Viking CCS Pipeline

SCOPING OPINION:

Proposed V Net Zero Pipeline Project

Case Reference: EN070008

Figure 2-3: Schematic of Corridor Options and Indicative Preferred Corridor

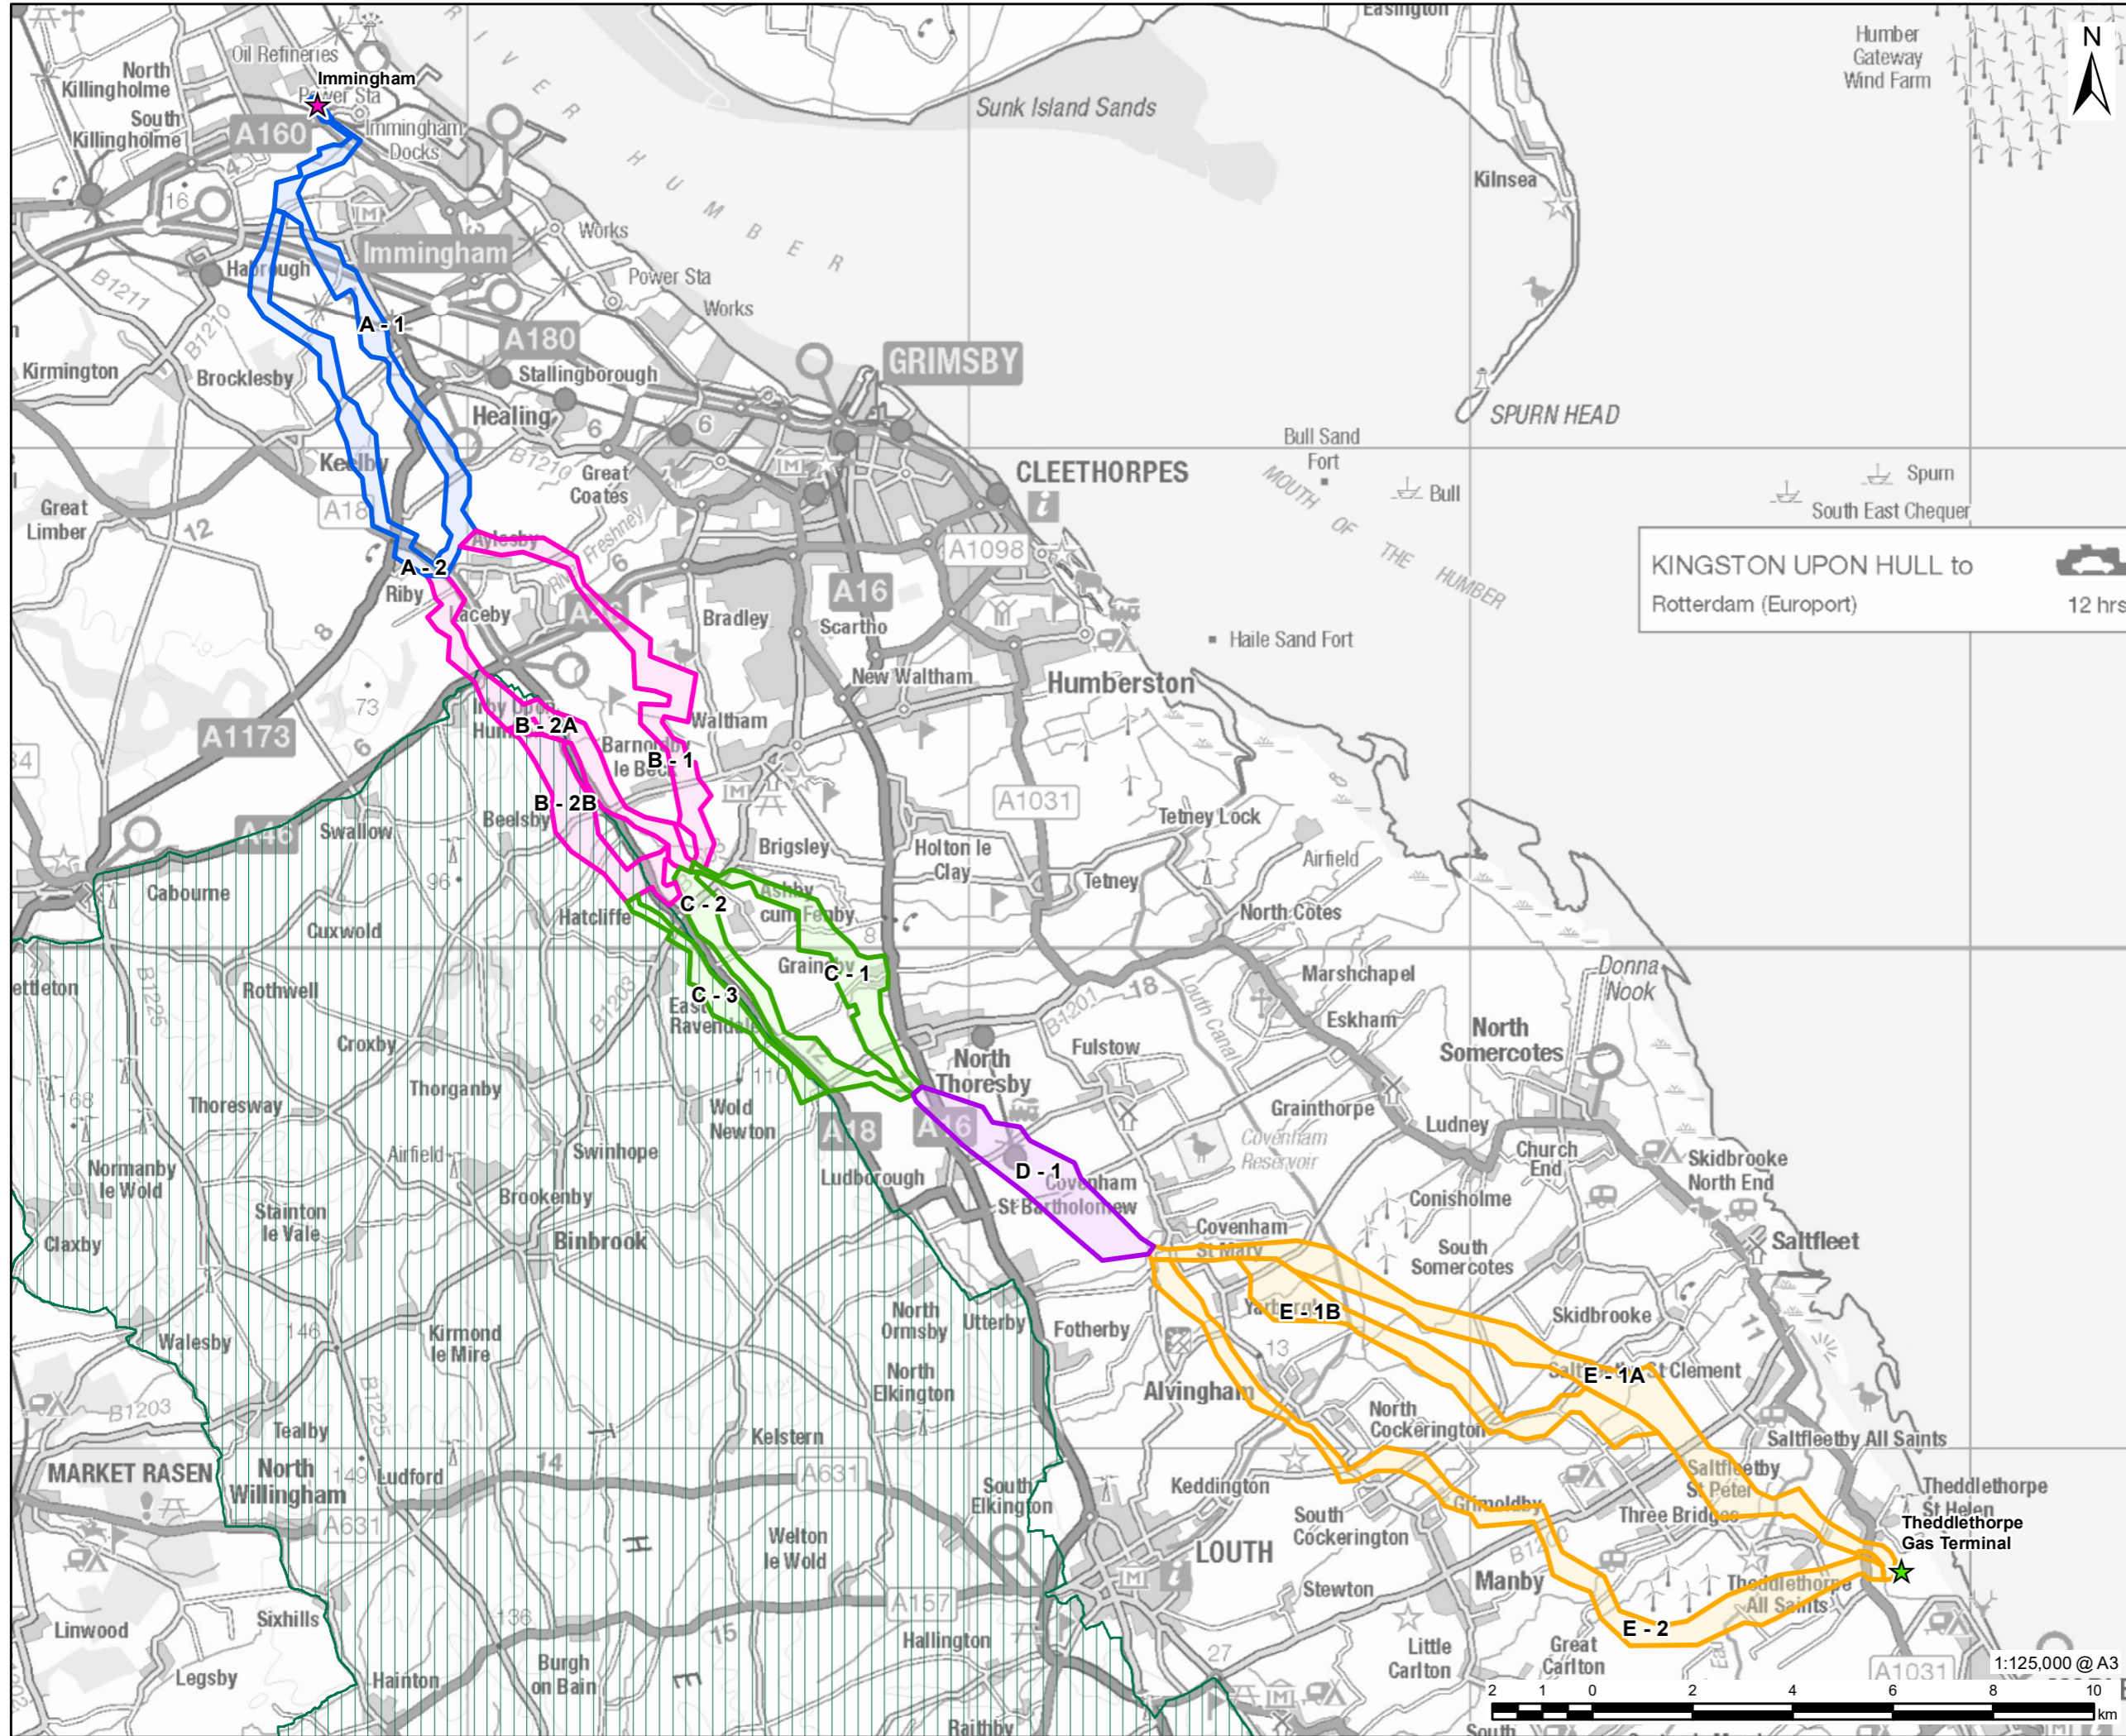
ID	Ref	Description	Inspectorate's comments
2.1.1	Figure 2-3	Unidentified mapped feature	Figure 2-3 (3 of 3) shows a series of green lines offshore at Saltfleet. It is not clear from the key what feature the lines represent. All figures presented in the ES should be clear and complete.
